From: Jeremiah Cromie <jeremiah.cromie@co.kittitas.wa.us>
Sent: Tuesday, July 27, 2021 10:29 AM
To: Samantha Cox <samantha.cox@co.kittitas.wa.us>; Holly Erdman <Holly.erdman@co.kittitas.wa.us>
Cc: Jeremy Johnston <jeremy.johnston@co.kittitas.wa.us>
Subject: Map of Proposed Wells for Tiger, Wildcat and Timothy Plats

SUBJECT: Timothy Short Plat SP-08-00018

RE: SP-08-00018

SUBJECT: Timothy Short Plat SP-08-00018 – Updated Comments

Proposed Shared Wells (up to 3 wells)

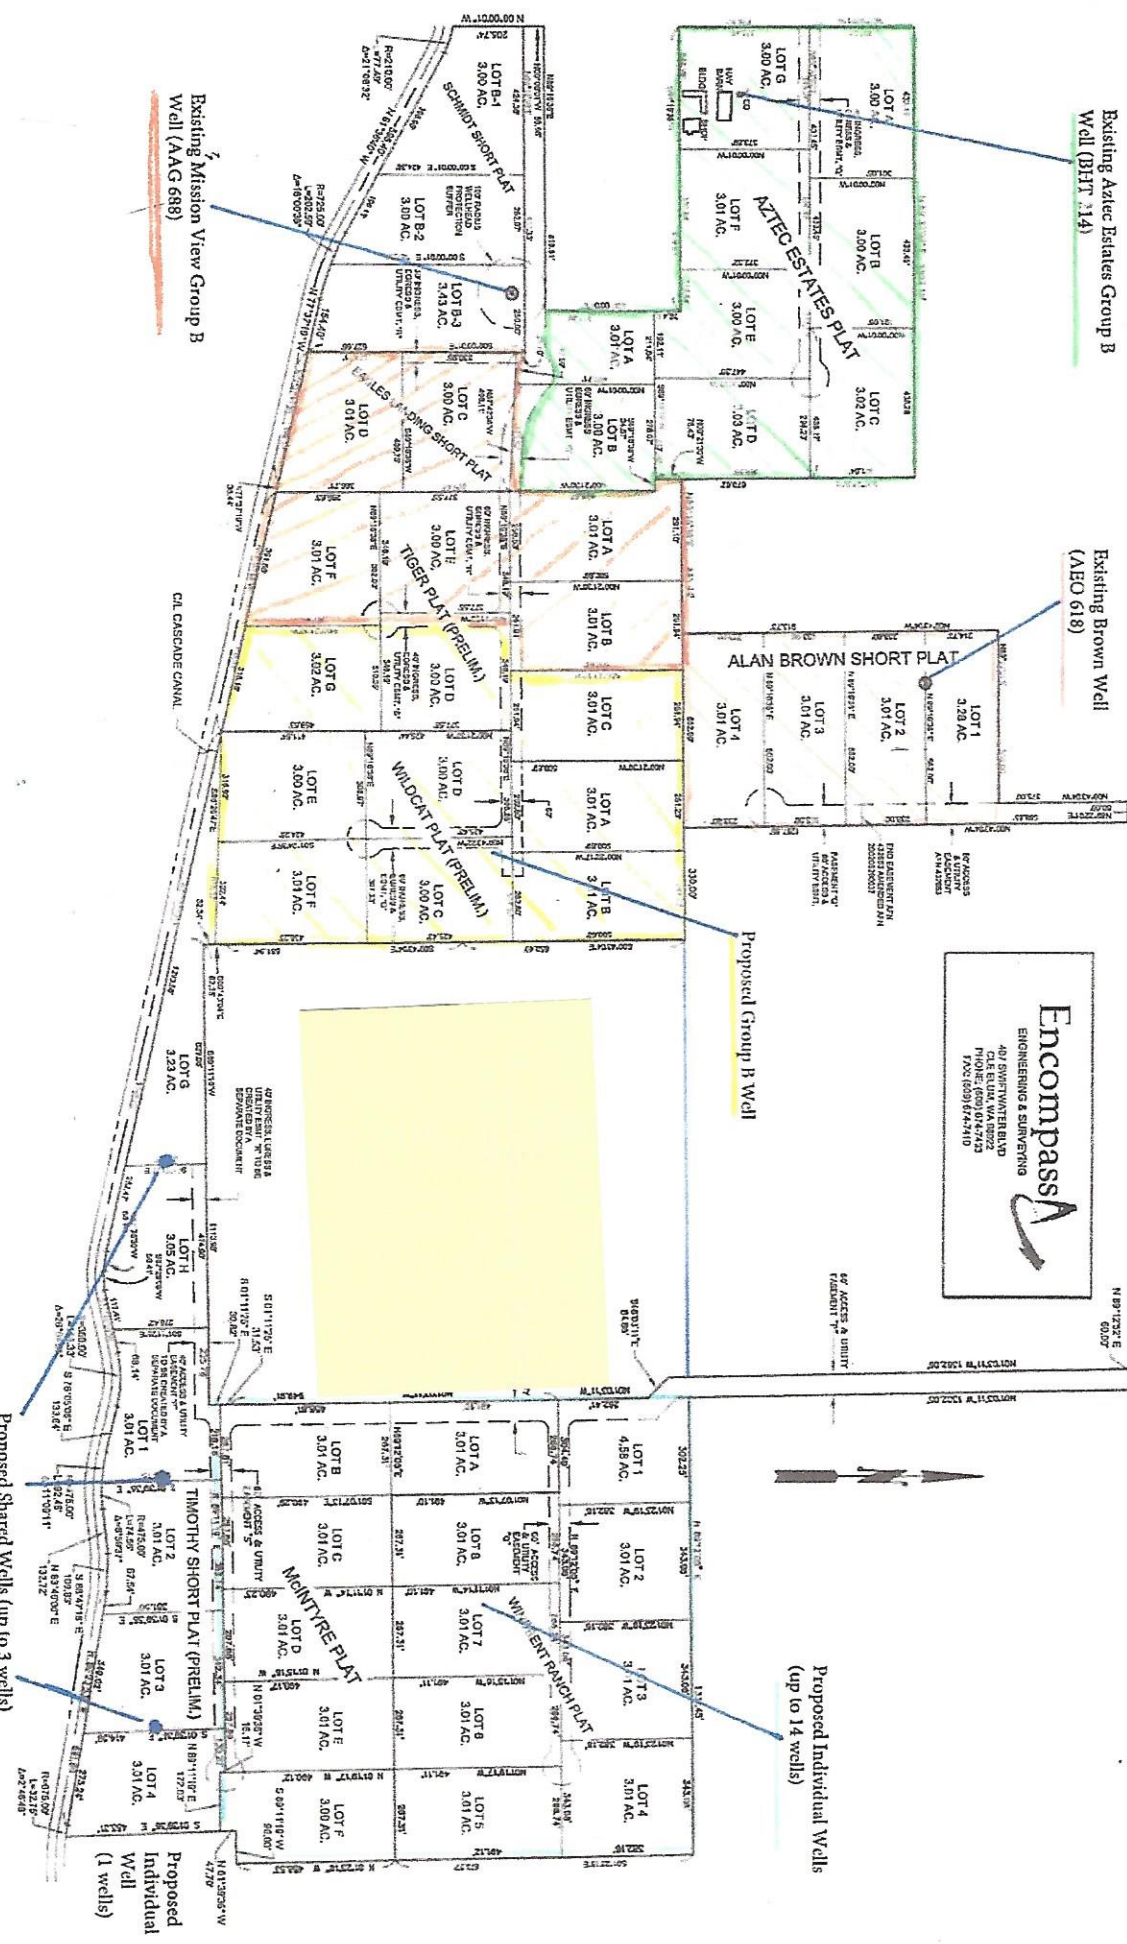
A well site inspection needs to be done to approve the well AEO618 as a Group B well. A well site inspection also needs to be done to approve the well for the Wildcat Plat well. The proposed shared wells on the Timothy SP wells need to be moved so they are at least 50 feet from all property lines. All proposed individual and shared wells must have approved individual well site review applications submitted and approved.

TIMOTHY SHORT PLAT
A PTN. OF SEC. 32, T. 18N, R. 19E, W.M.
KITITAS COUNTY, WASHINGTON

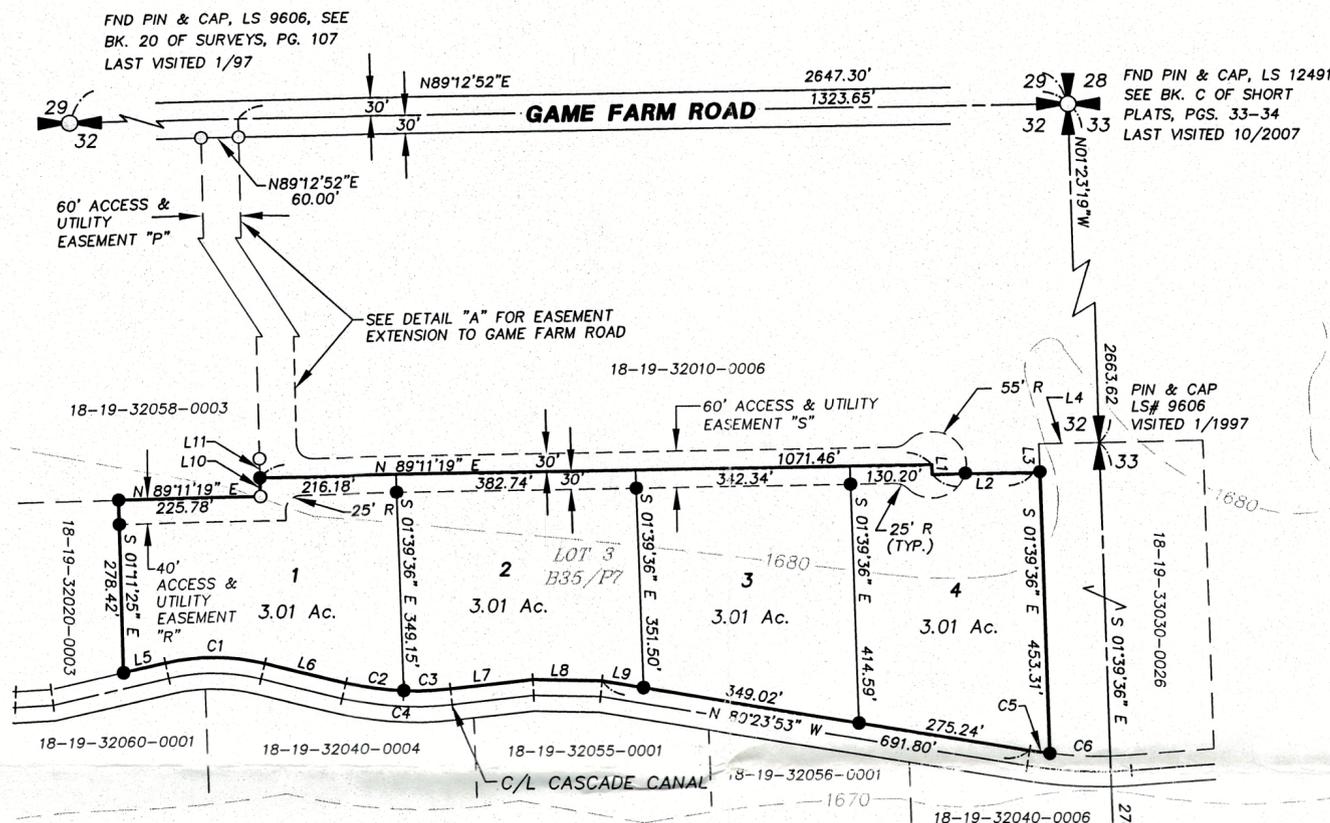
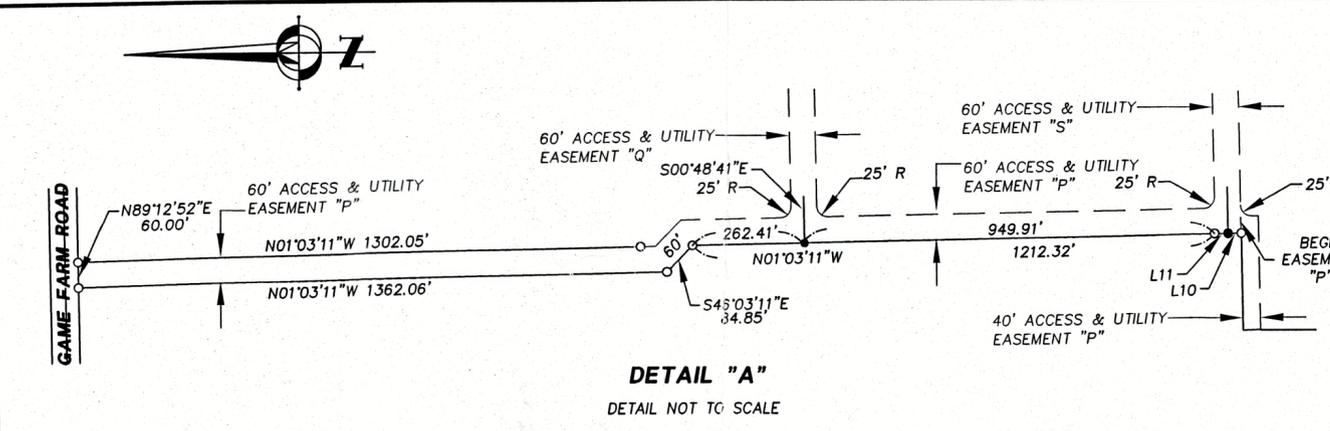
1. For the 60' access easement, please reference AFN200710220075, 201010050029 and 201010050030.
2. The Plat will need to be stamped and signed by a surveyor actively licensed in the State of Washington.
3. Adjacent property owners list will need to be updated.
4. An updated title report will need to be reviewed prior to final approval for the Timothy Short Plat.

1. For the 60' access easement, please reference AFN 200710220075, 201010050029 and 201010050030.
2. The Plat will need to be stamped and signed by a surveyor actively licensed in the State of Washington.
3. Adjacent property owners list will need to be updated.
4. An updated title report will need to be reviewed prior to final approval for the Timothy Short Plat.
